June 30, 2022
File: SNC-2698-2022
ROLL No: 061460023012200 &
061460023012202

**Subject: Site Plan Proposal D07-12-21-0205
6150 Thunder Road & 5368 Boundary Road
Lot 1, Concession 9 (Gloucester)
Thunder Road Developments (2019) Inc.;
Exit 96 Developments Inc.**

DRAWING TITLE
**EROSION AND SEDIMENT
CONTROL PLAN**

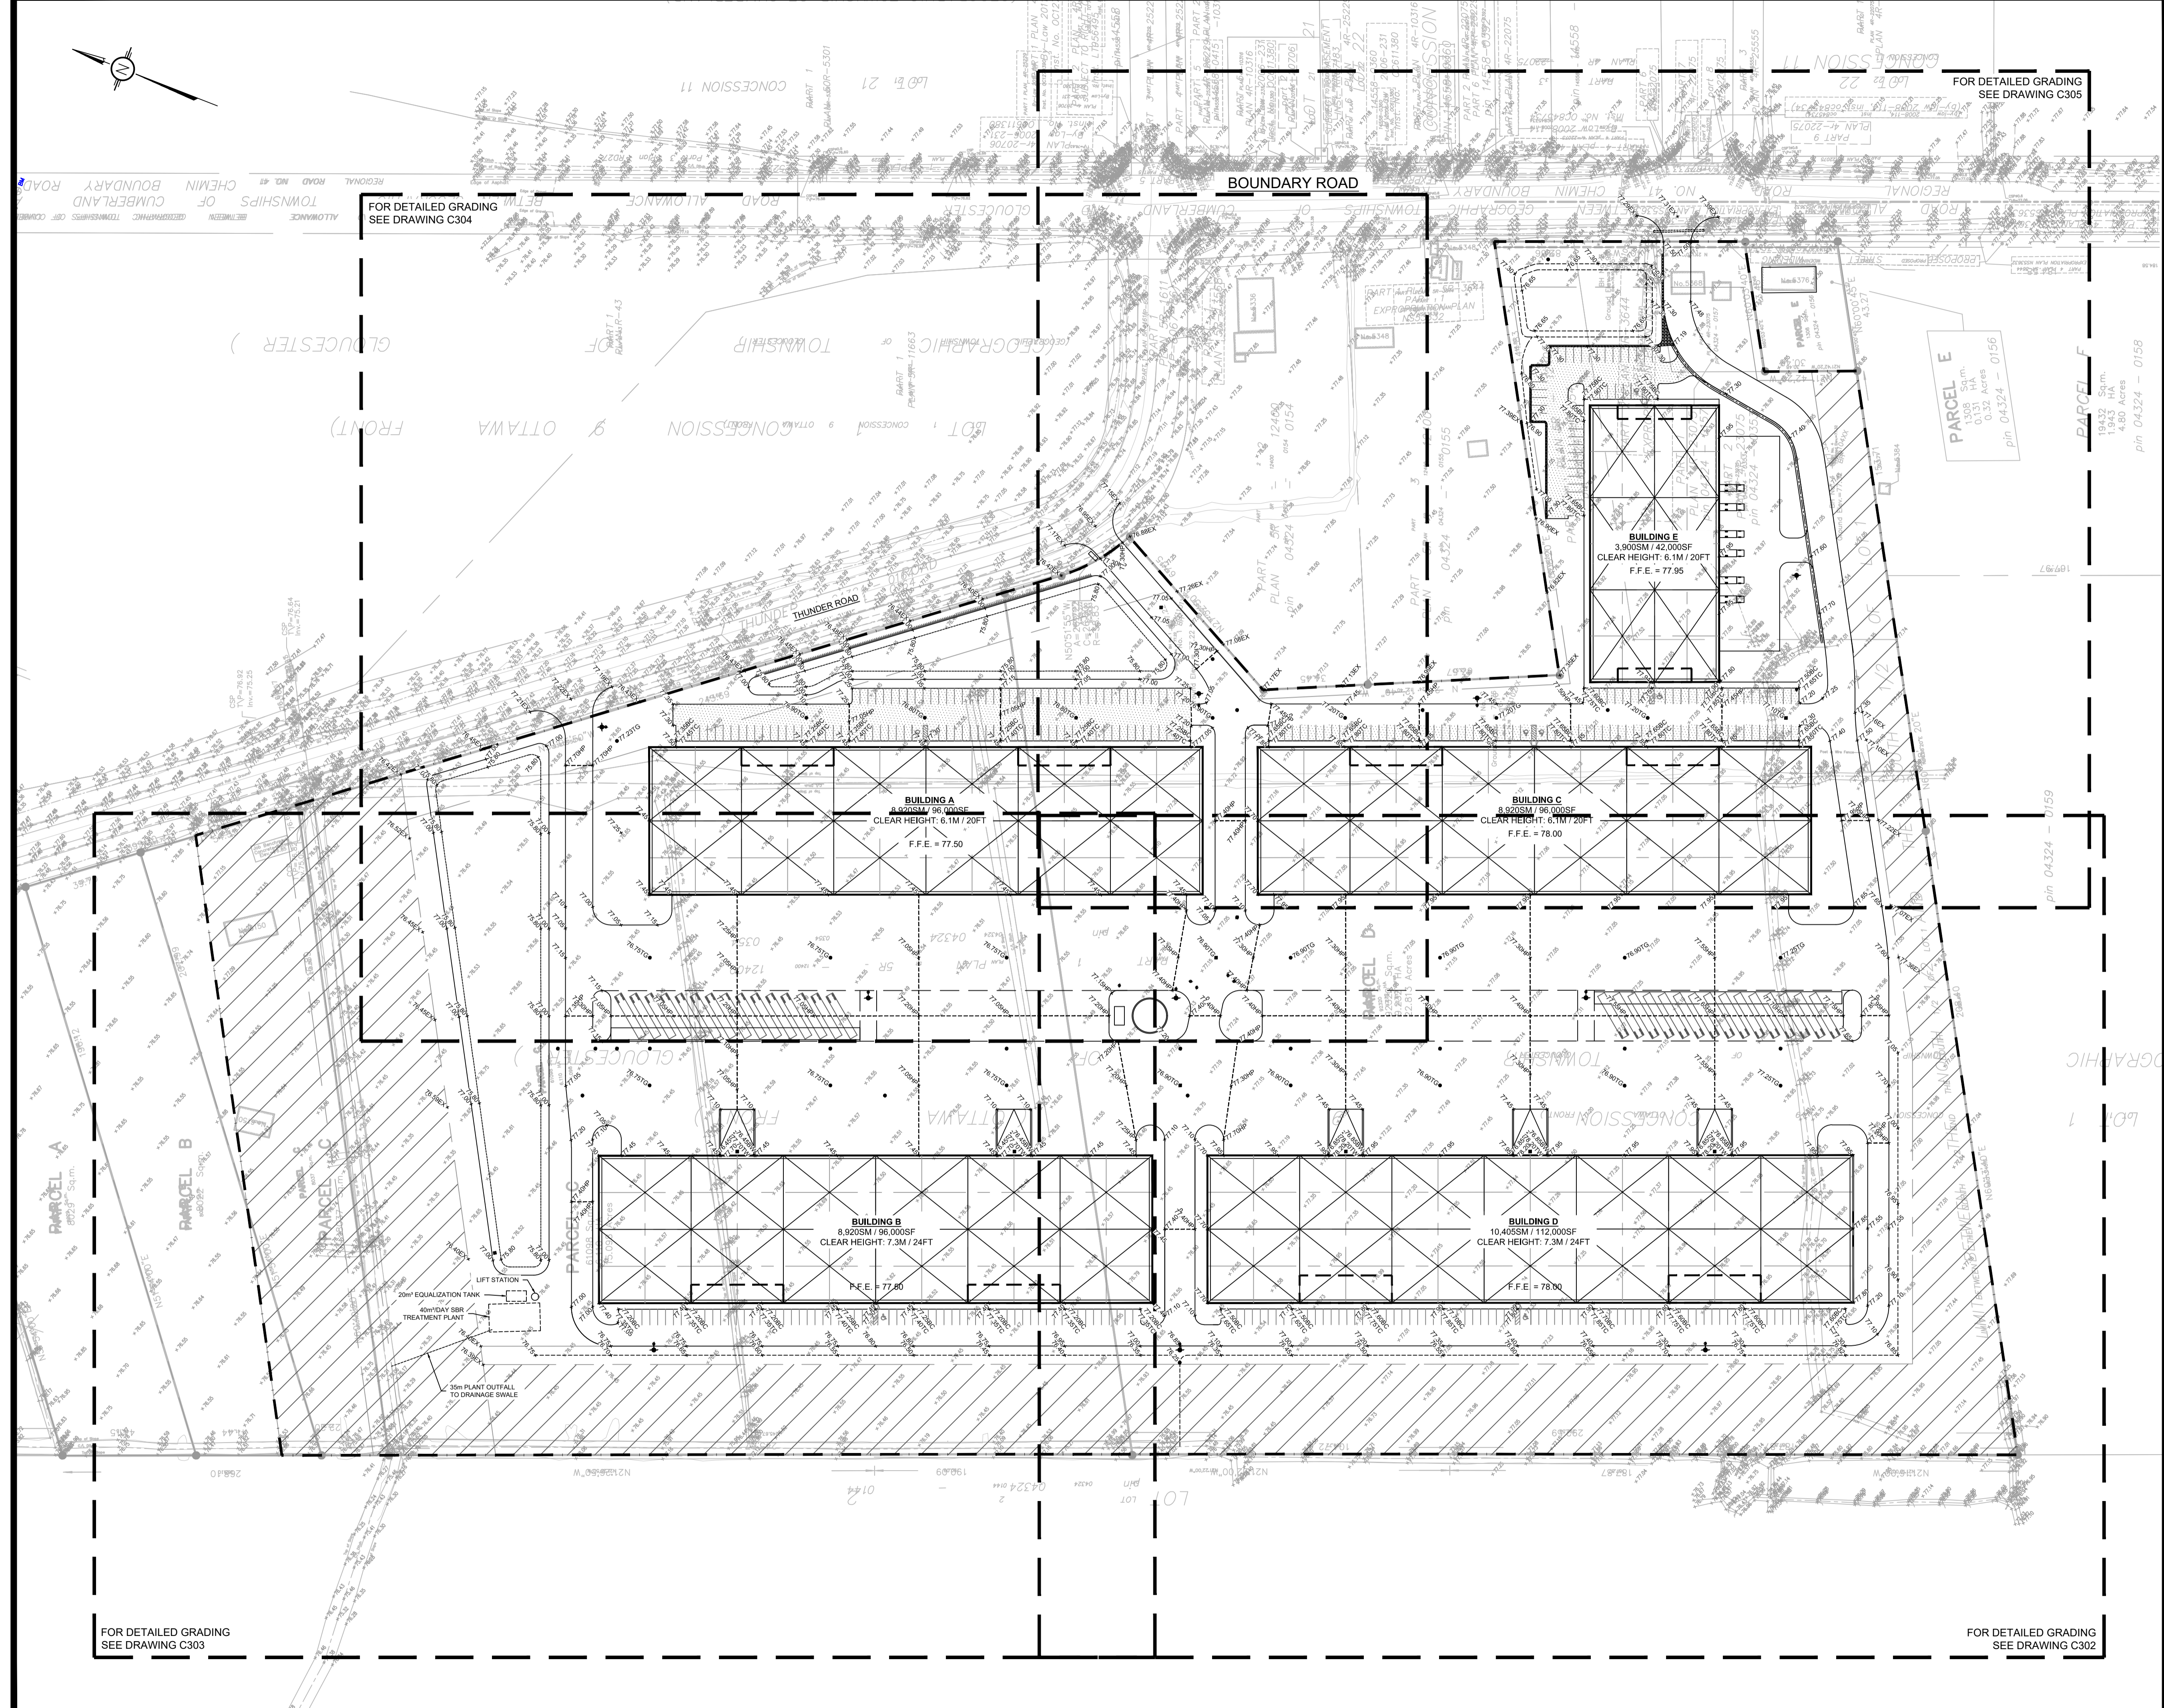
11. A separate signed and stamped Sediment and Erosion control plan is required demonstrating how the receiving watercourses are protected. The Sediment and Erosion Control plan will:

- a) Identify who is responsible to install inspect, maintain and remove the control measures
 - b) Identify the inspection and maintenance schedule (how, when, how often i.e. daily/weekly)

- c) Indicate which control measures are proposed, a legend, their location and corresponding OPSD number
 - d) Indicate that it is to be considered a "Living Document" which may be modified in the event the control measures are insufficient.

- e) Provide details and sizing calculations on permanent erosion protection measures at all outlets.

DRAWING TITLE
STORMWATER MANAGEMENT PLAN

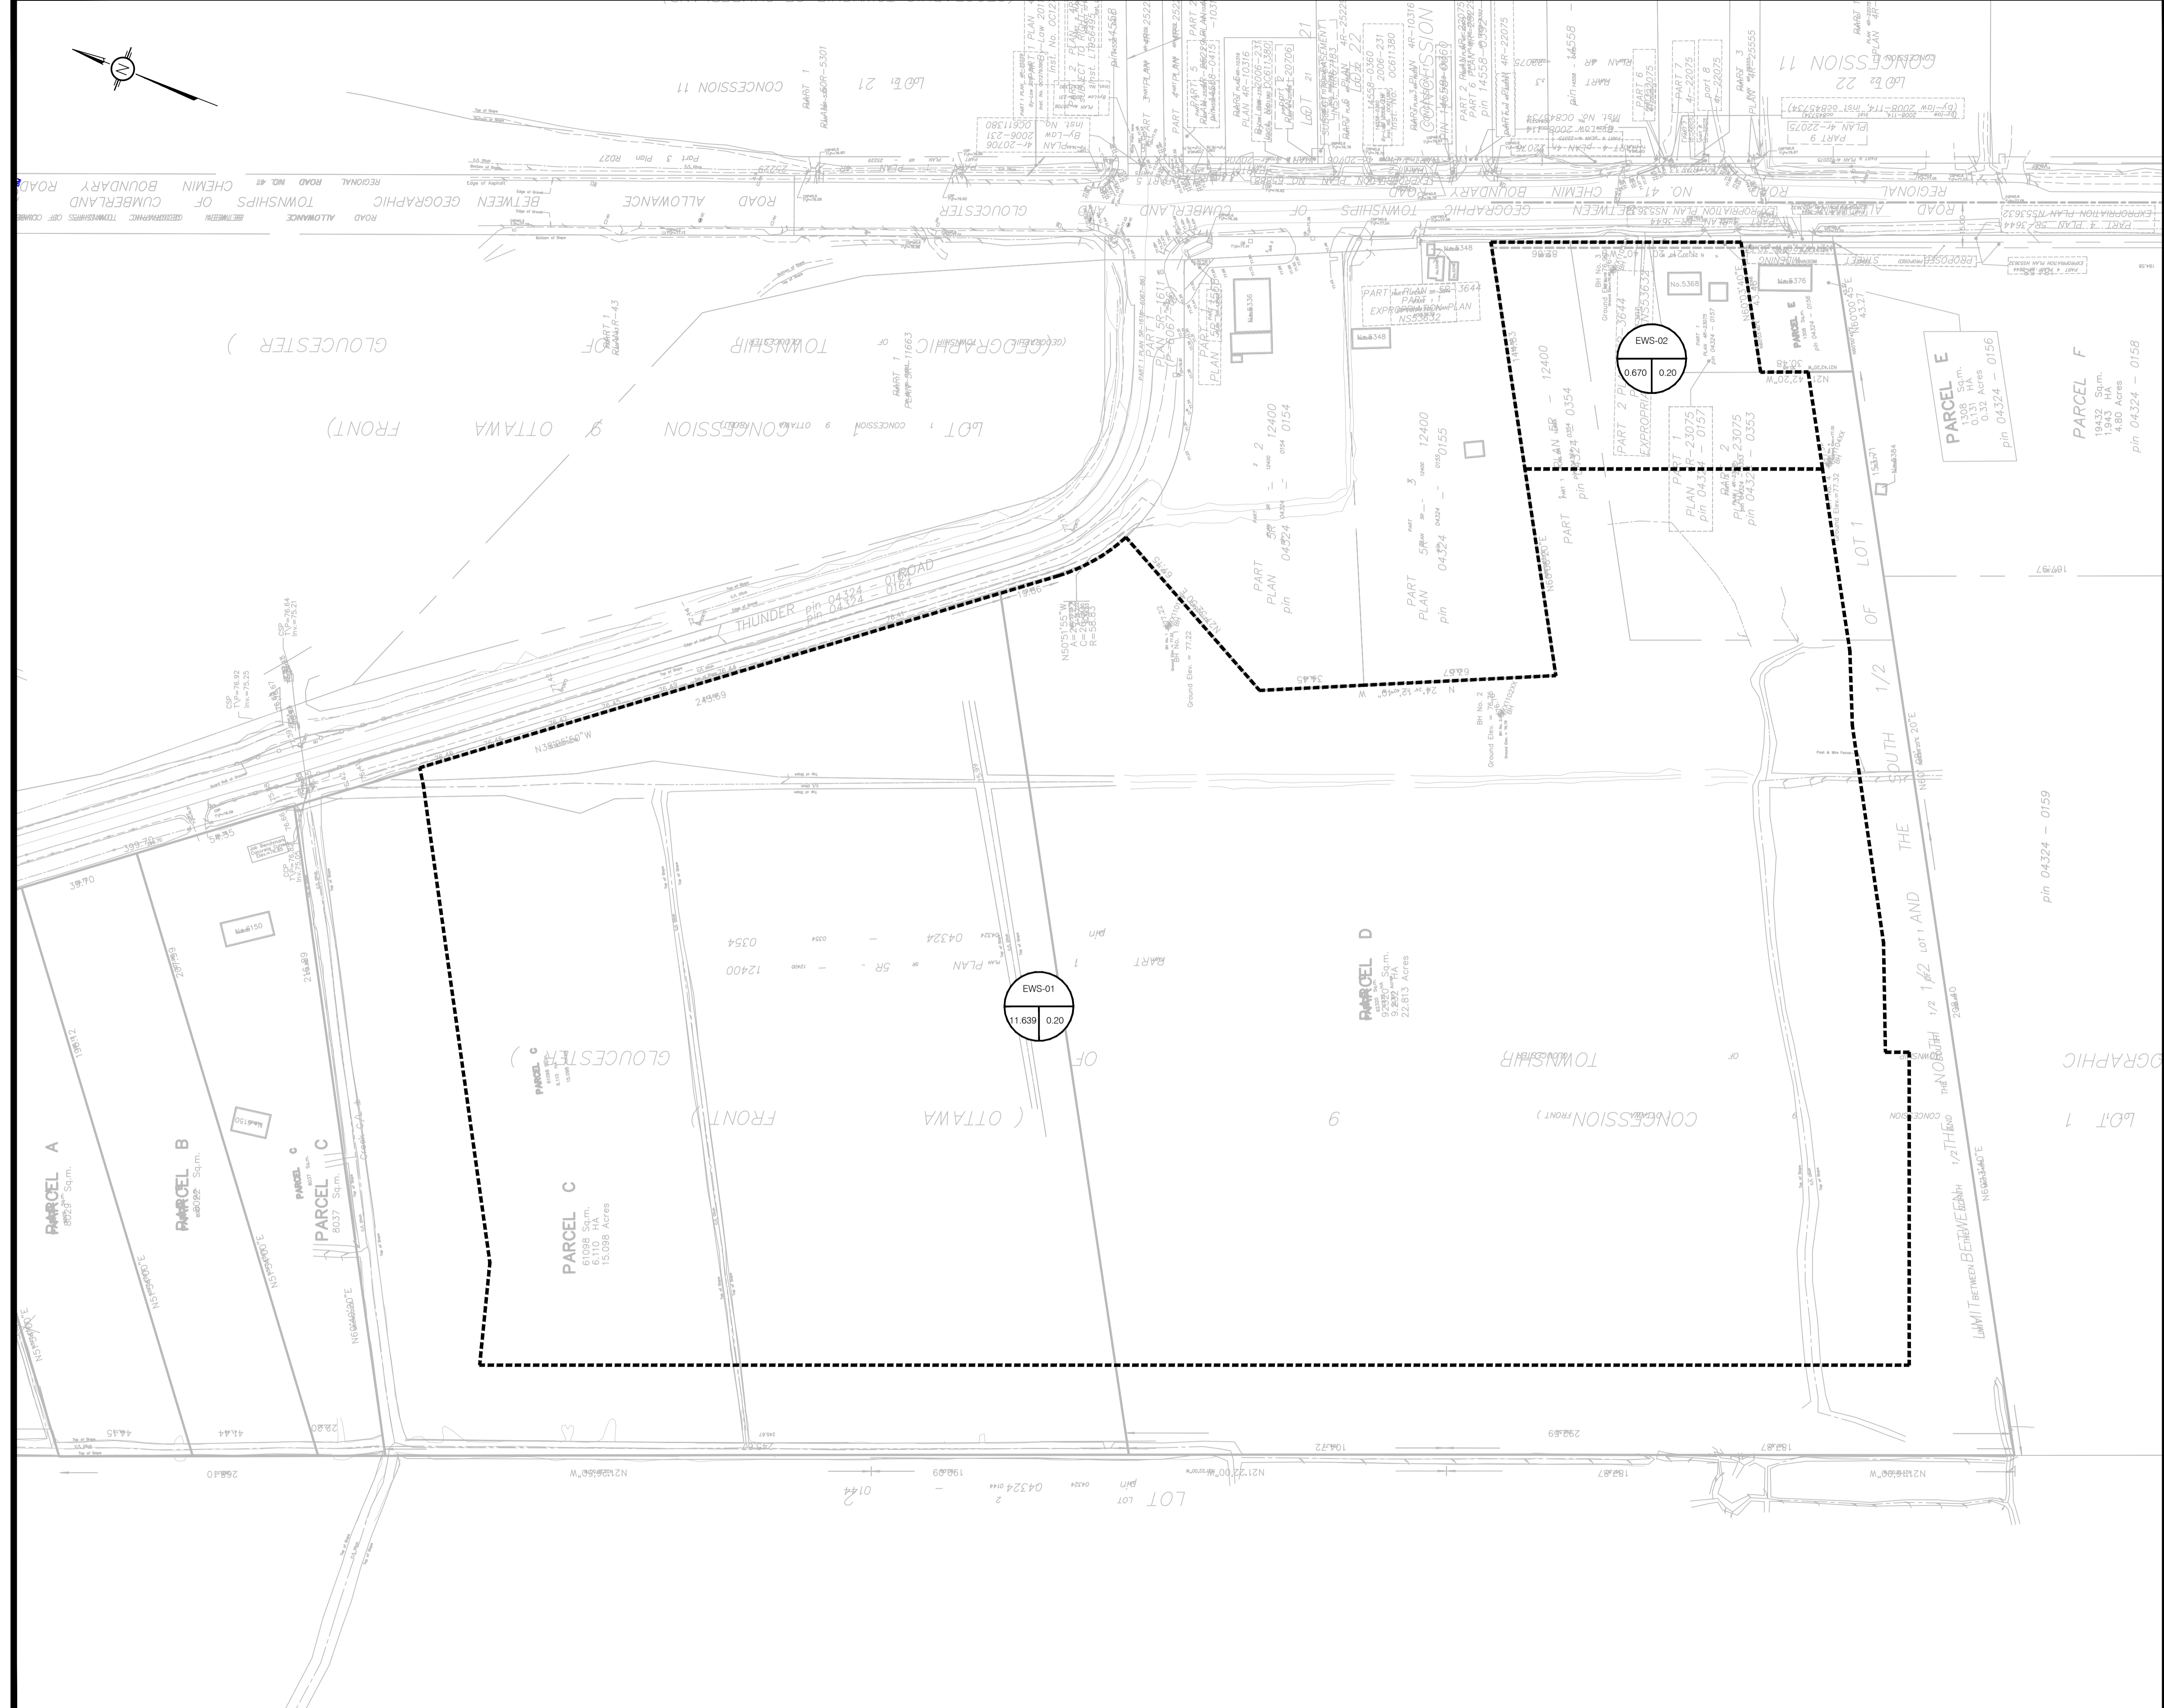
8. The report states that 80% TSS will be removed. Future submissions should provide design details. Sizing reports and/or supporting calculations demonstrating how 80% TSS will be achieved.

9. It should be noted that the flood plain elevation immediately downstream of the outlet is 75.86 m. With the invert of the outlet pipe set at 75.70m and the bottom of the pond set at 75.80 m. How will the storm facility function during a major storm event?

10. The groundwater appears to be near surface at areas throughout the site and where proposed ponding areas are located. How will groundwater be mitigated to not impact the construction and function of the stormwater management facilities as well as not be impacted by potential contamination?
